From: Nicola Moore on behalf of Planning.Responses
Sent: 29 June 2020 14:37
To: Planning Scanning
Subject: FW: Consultation response for EP/62/20/DOC

From: Sarah Burrow <Sarah.Burrow@arun.gov.uk>
Sent: 26 June 2020 16:08
To: Anita Gardner <Anita.Gardner@arun.gov.uk>
Cc: Planning.Responses <Planning.Responses@arun.gov.uk>
Subject: Consultation response for EP/62/20/DOC

Engineers Comments Regarding Surface Water Drainage

Scales: 1:20 1:200 No: 2386/01/13

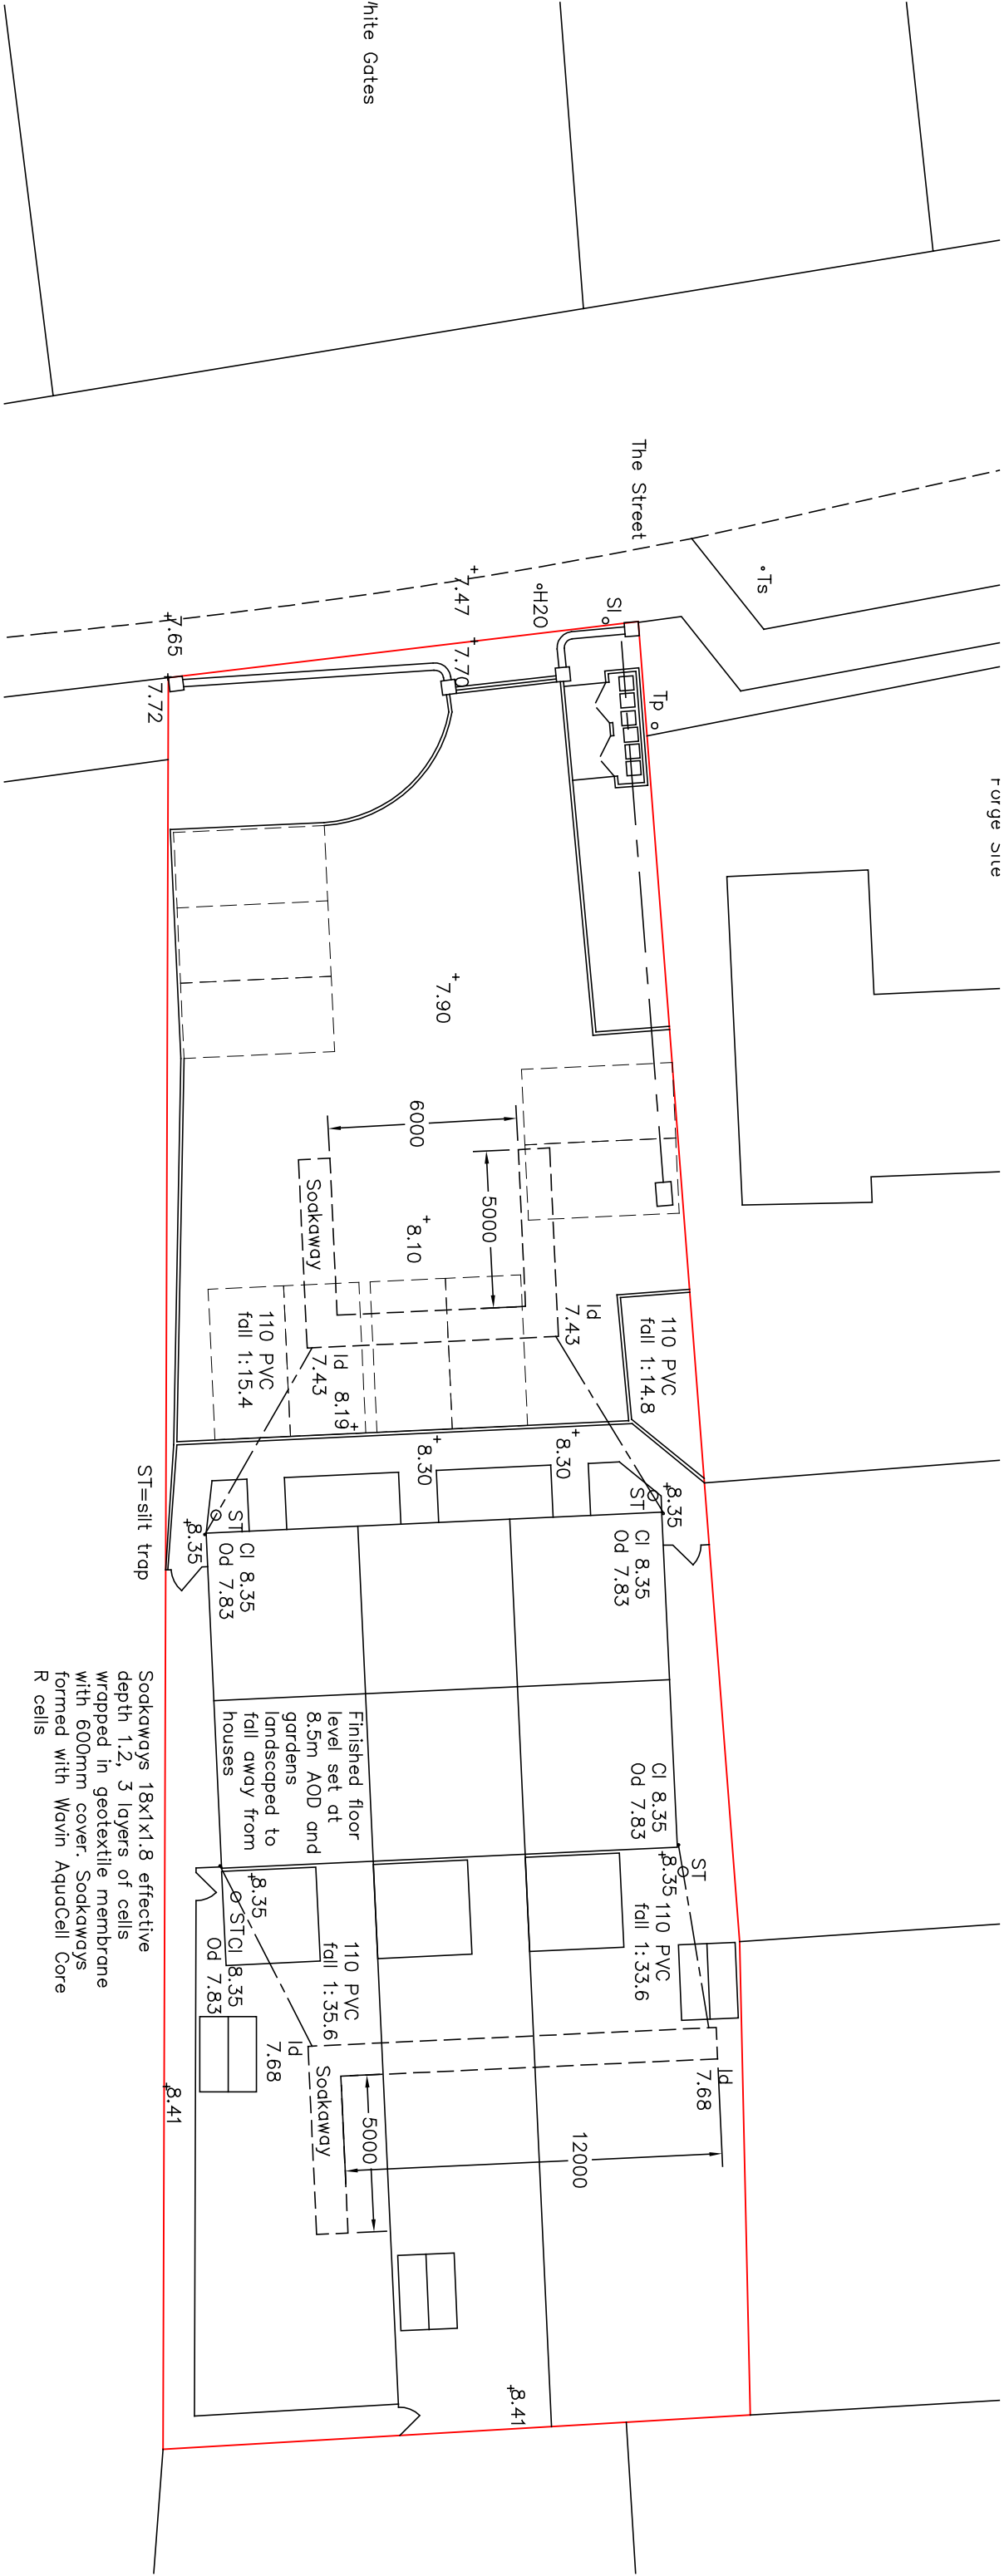
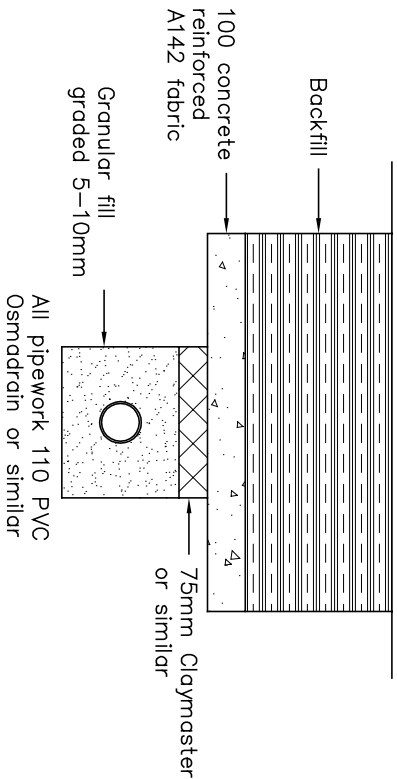
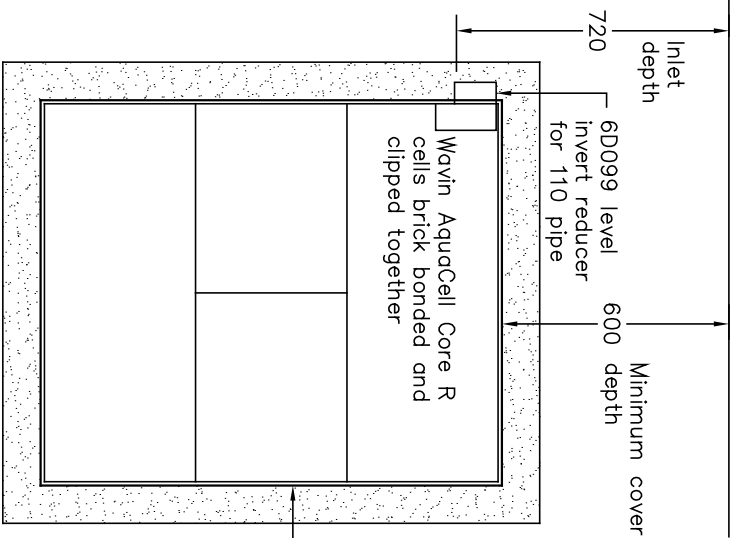
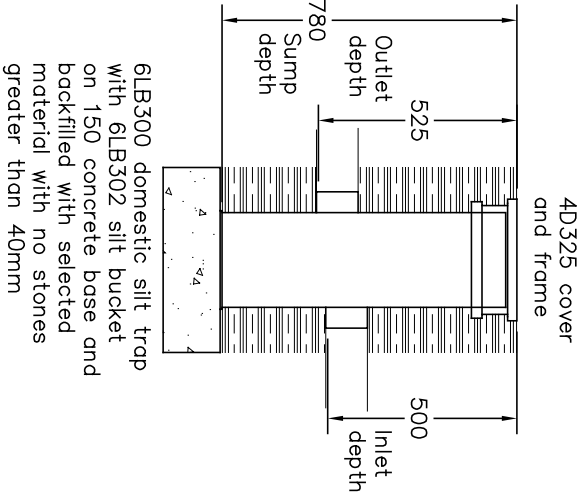
The infiltration rate on the site is very low (1.07×10^{-6}), it is not possible to achieve a half drain time of 24 hours. As a result the agent proposed upsizing the soakaways to hold up to 3x 1 in 100 year storms, allowing for additional inflow whilst the soakaways drained. Whilst the situation is undesirable we agreed that this was a reasonable solution. However, we would need to see an exceedance flow route, or topographical levels that showed that any excess flow (if the soakaways reached capacity or became blocked) would be directed away from the properties. This has not been supplied as part of the application. In addition, the soakaway dimensions described on the plan do not reflect the dimensions on the calculations (which would not meet the criteria discussed).

1. The applicant needs to supply a stand alone drainage layout, this should include the following details:

- a. Dimensions of each soakaway (ensure these match the calculations), invert levels and cover levels also need to be labelled. The soakaway crates should be specified and suitable for vehicular loading at the depths proposed.

- b. Show all pipes, these should be labelled with diameters, pipe materials, falls and invert levels (at ends).
 - c. Location of any manholes/inspection chambers, including their cover levels, invert levels, and cover types.

- d. Silt traps which must be included upstream of any connection to a soakaway. Also labelled with invert and cover levels, ideally also sump levels.

2. Supply an exceedance flow route and/or topographical levels that show that any exceedance flow will be directed away from any buildings.
 3. Supply construction detail drawings for all components:

- a. Soakaways
 - b. Pipe bed and surrounds
 - c. Manholes/inspection chambers
 - d. Silt traps
 4. Amend and submit calculations to reflect the soakaways specified.
